WA/66/18/DOC

Condition 13 is of interest to me as it relates to the provision of details for the refurbishment of the existing vehicular entrance gates. There are some concerns regarding the submission.

Application for approval of details reserved by condition imposed on planning permission WA/28/14/PL relating to condition 10 (Travel Plan Statement) and 13 (Entrance gates)

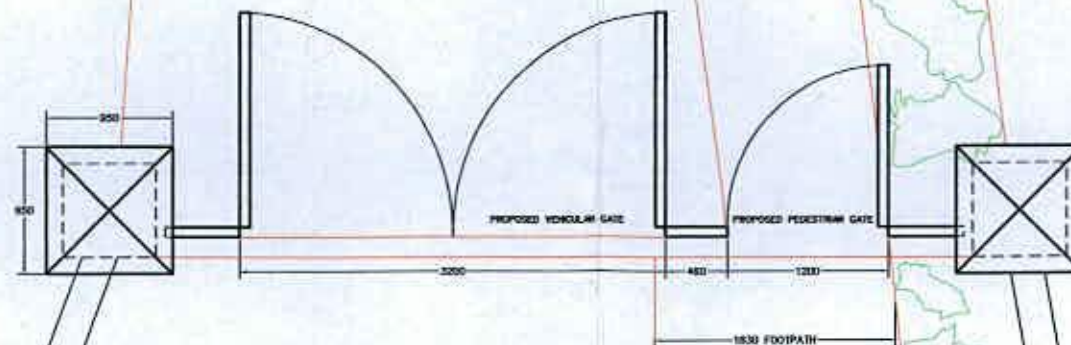
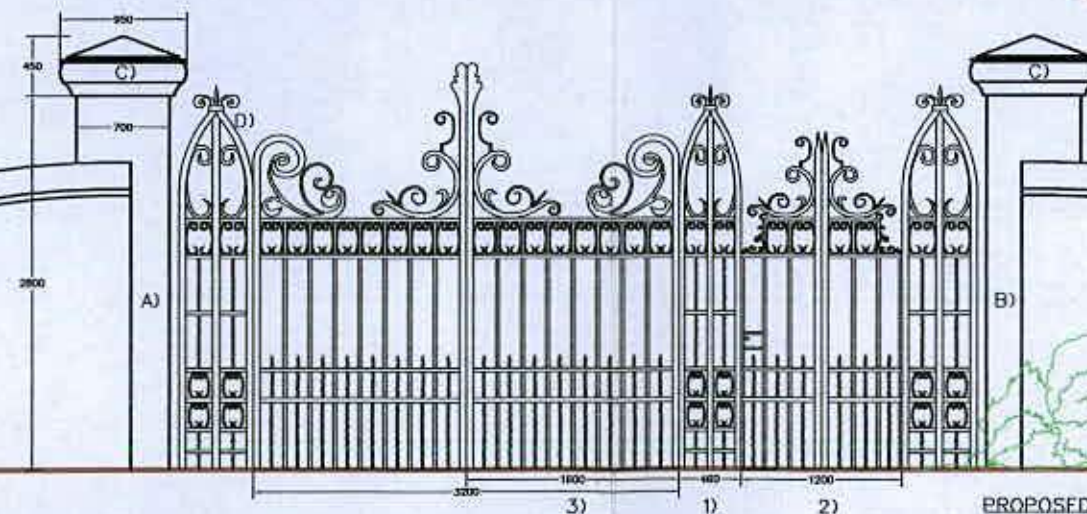
I note that two options have been provided as part of the submission. It is not clear which is the preferred approach from the application, or if they are seeking an answer from the LPA?

From a conservation perspective, the gates should reflect their historic appearance in order to maintain their significance. It is assumed that this approach would reflect the second option?

I note that the existing gates would be powder coated as part of the works. Such a proposal will surely damage the historic fabric that the applicant wishes to preserve? Surely, it would be better to clean and paint the existing fabric.
